DOC18/26046-1  
DA 9297 MOD 4

**Mount Pleasant Coal Mine – Modification 4 (MOD 4)**

I refer to your e-mail dated 15 January 2018 inviting the Office of Environment and Heritage (OEH) to review the Environmental Impact Statement for the proposed modification to the Mount Pleasant Coal Mine (DA 9297 MOD 4).

Figure 6.4 - Peak flood level impacts, 5% AEP design event

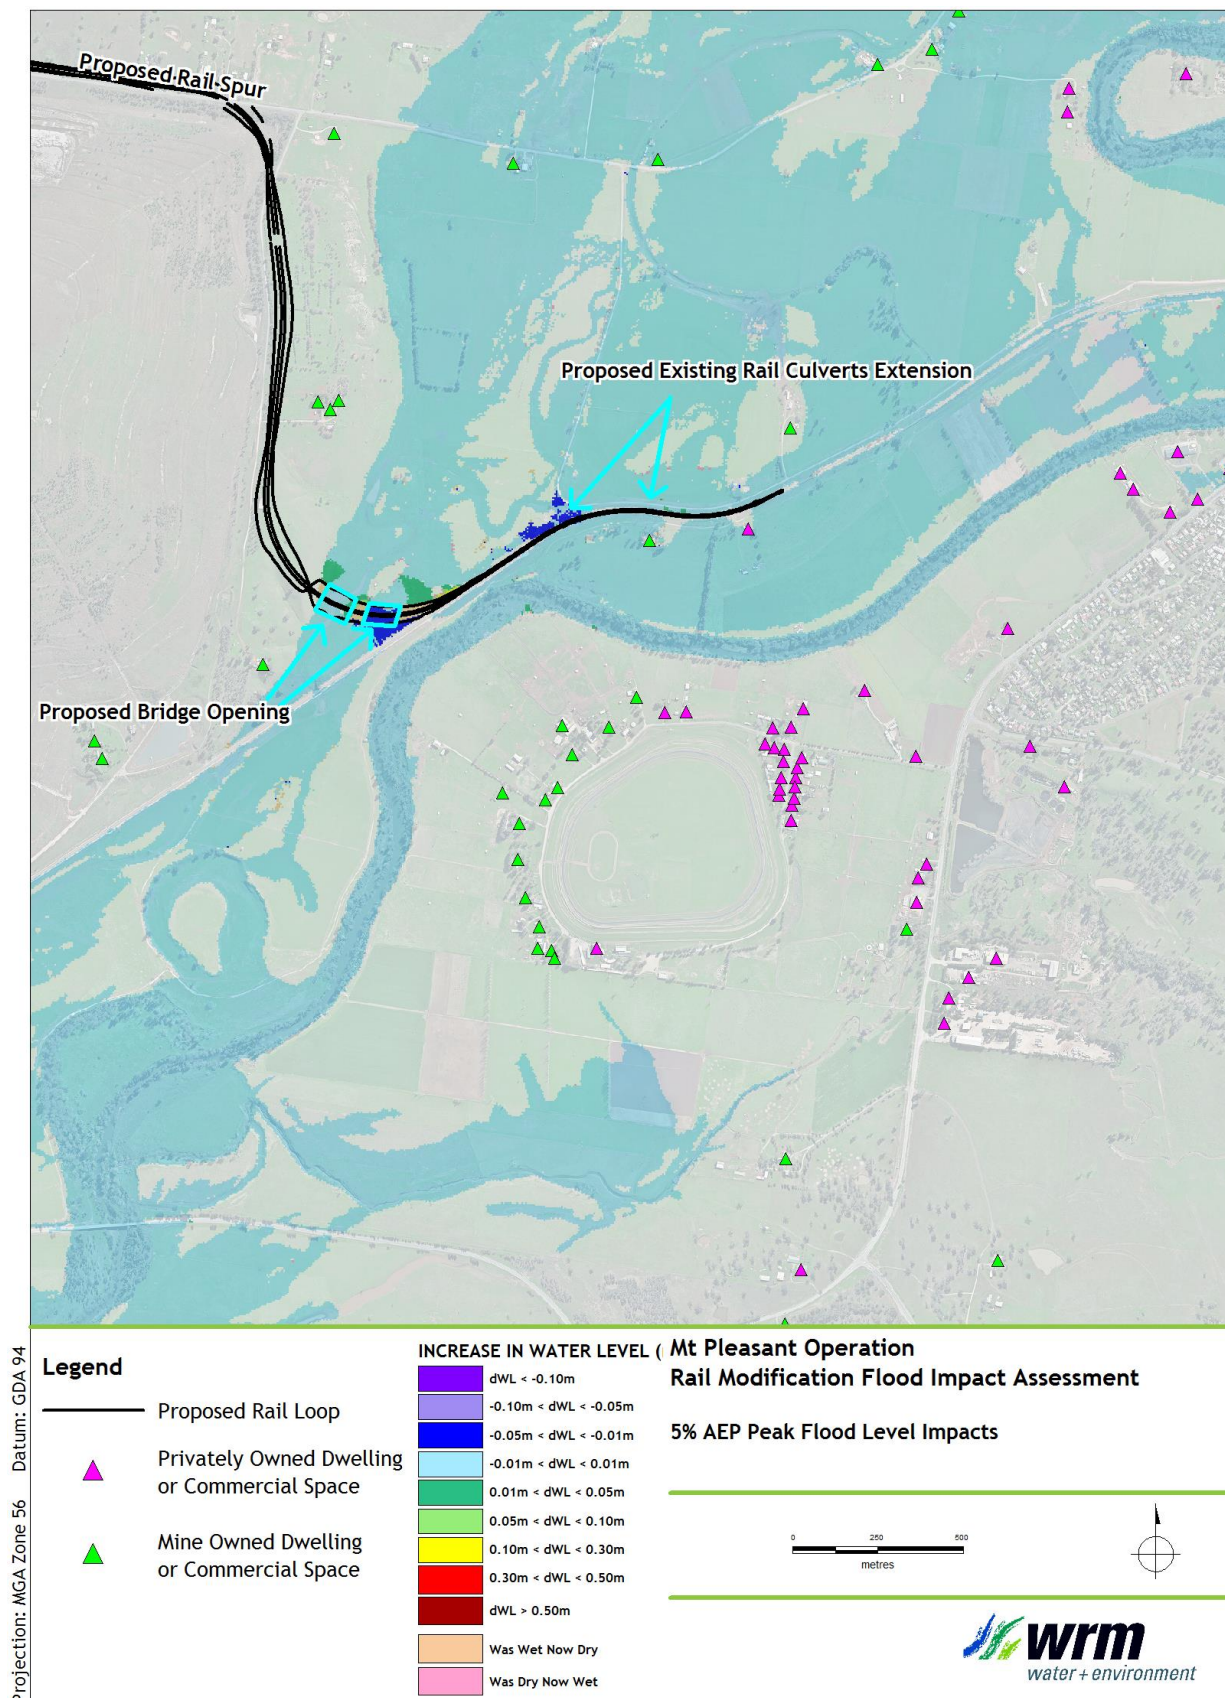
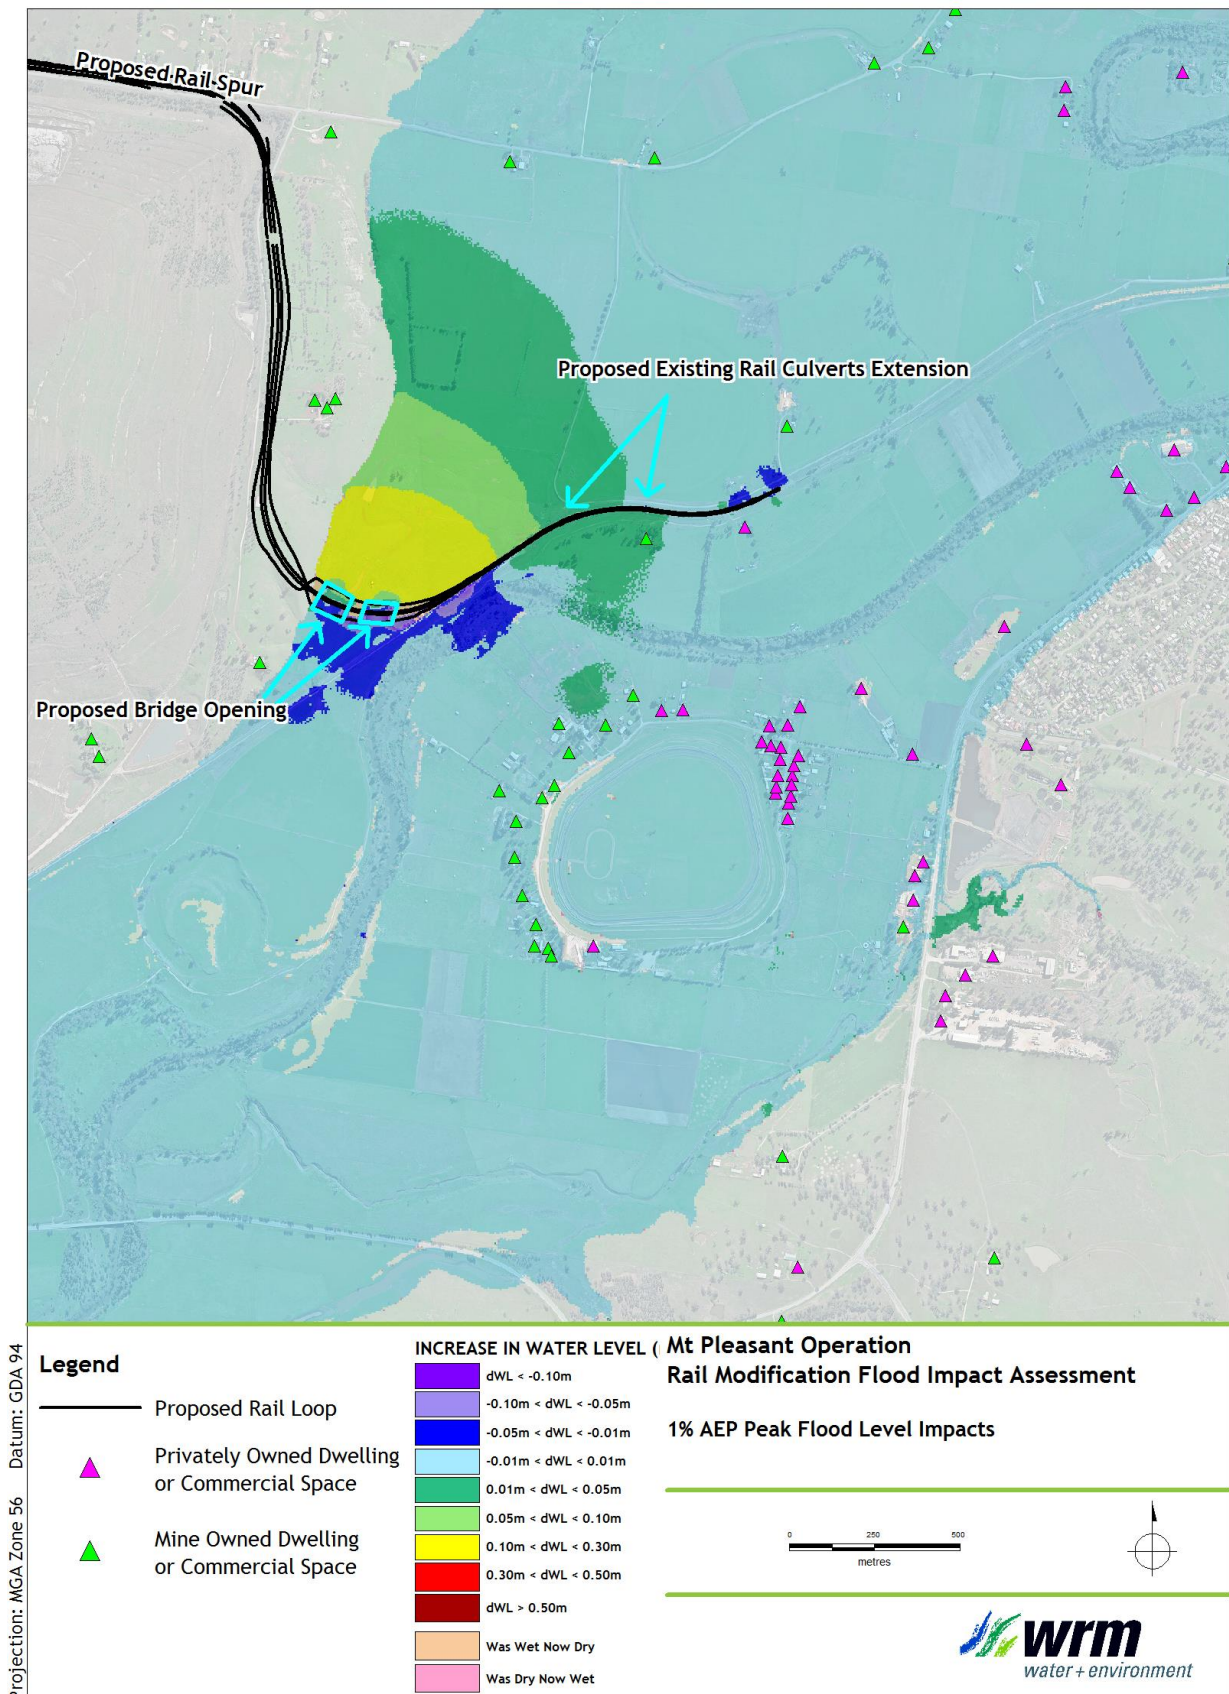
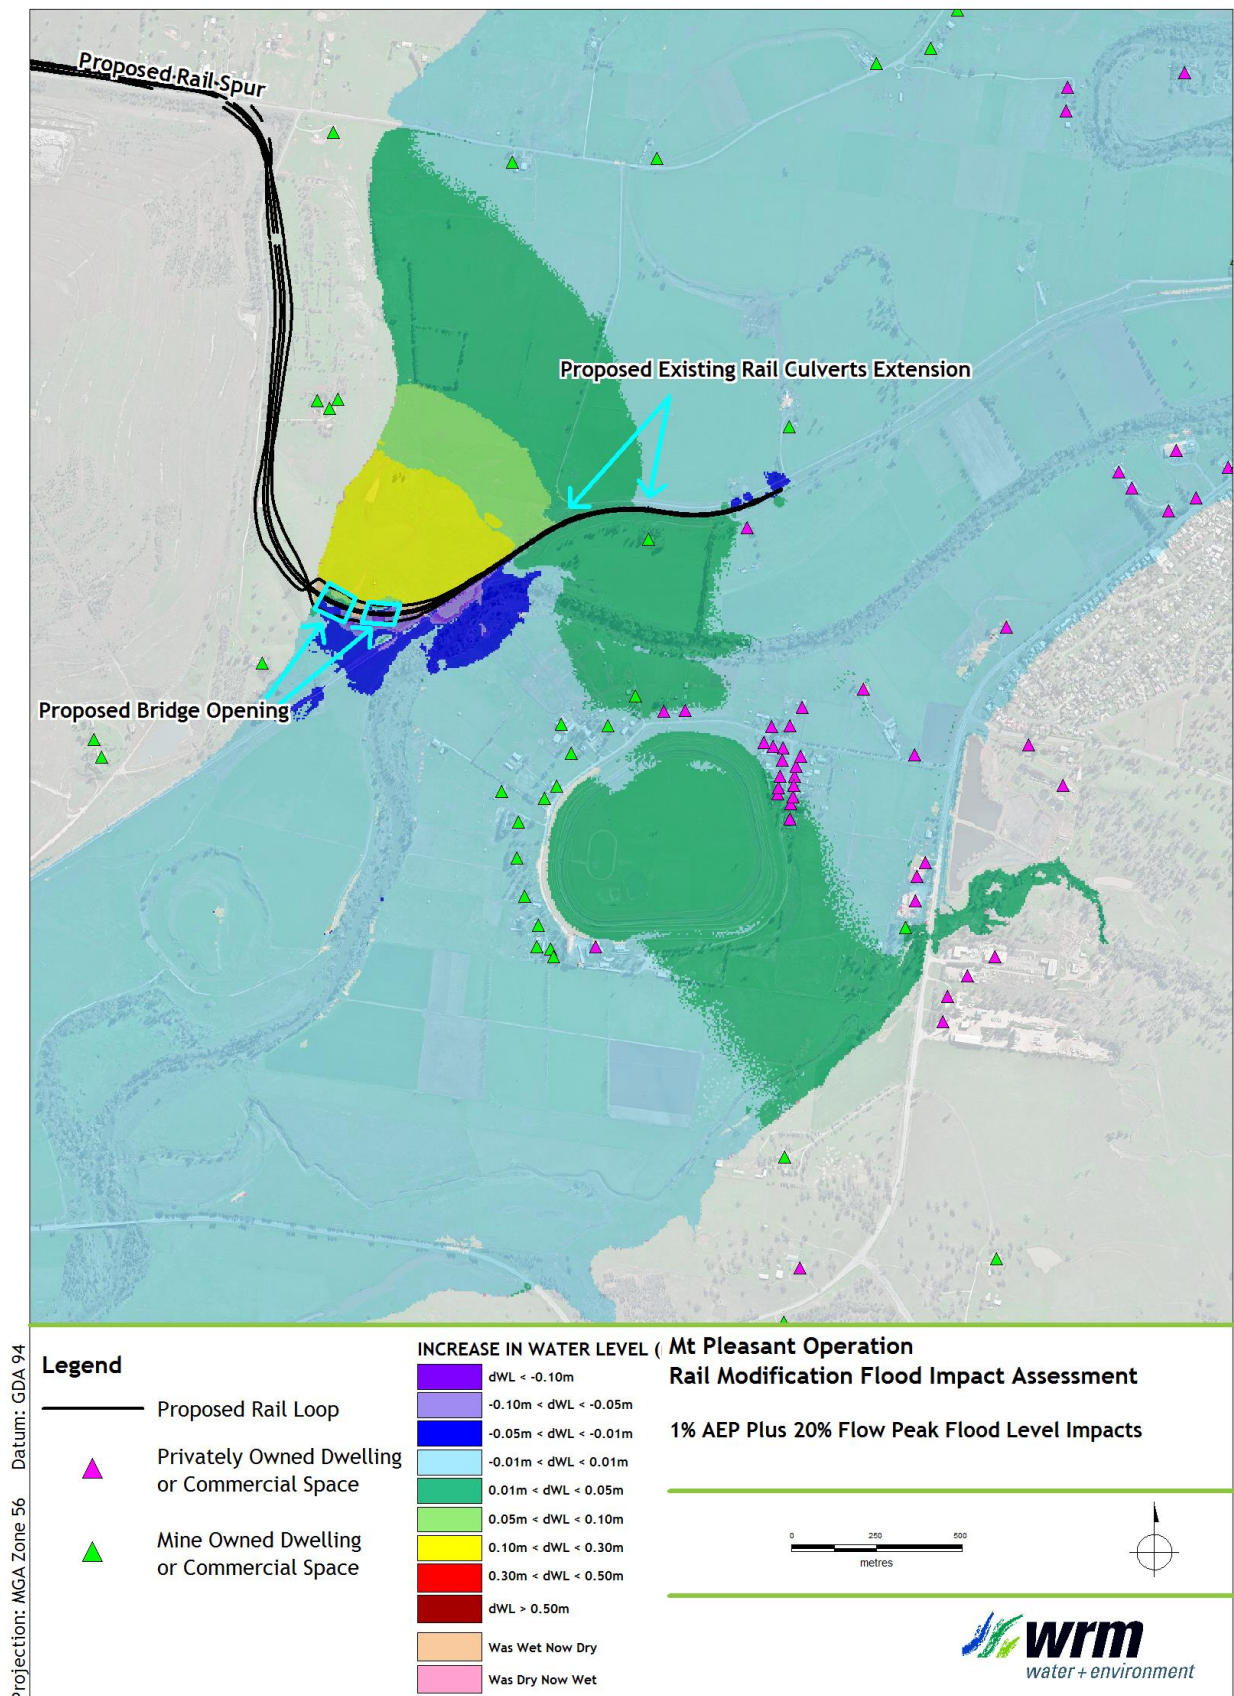
Section 6 of the flood study includes predicted flood level impacts because of the modification, which includes proposed mitigation measures. These impacts are currently indicated as up to 0.01 metre on privately owned dwellings or commercial properties, however greater impacts are indicated on mine owned dwellings or commercial properties. These impacts are indicated as covering a significant amount of land, in extent up to Denman Road to the south and south-east. Impacts up to 0.10 could be considered minor and within the accuracy of the modelling and assumptions with the hydrologic and hydraulic modelling.

Further information is required for OEH to complete its assessment of the predicted flooding impacts of the project.

- section 4.3 of the flood study should include a box plot or a graph indicating the variability of the peak flows for the critical storm duration
- the potential impact of blockages of the existing culverts and the proposed bridge openings, in accordance with ARR 2016 requirements, should be included
- impacts for floods greater than the 1% AEP design flood event should be included, up to and including the Probable Maximum Flood (PMF), including the 0.5% AEP and 0.2% AEP design storm events.
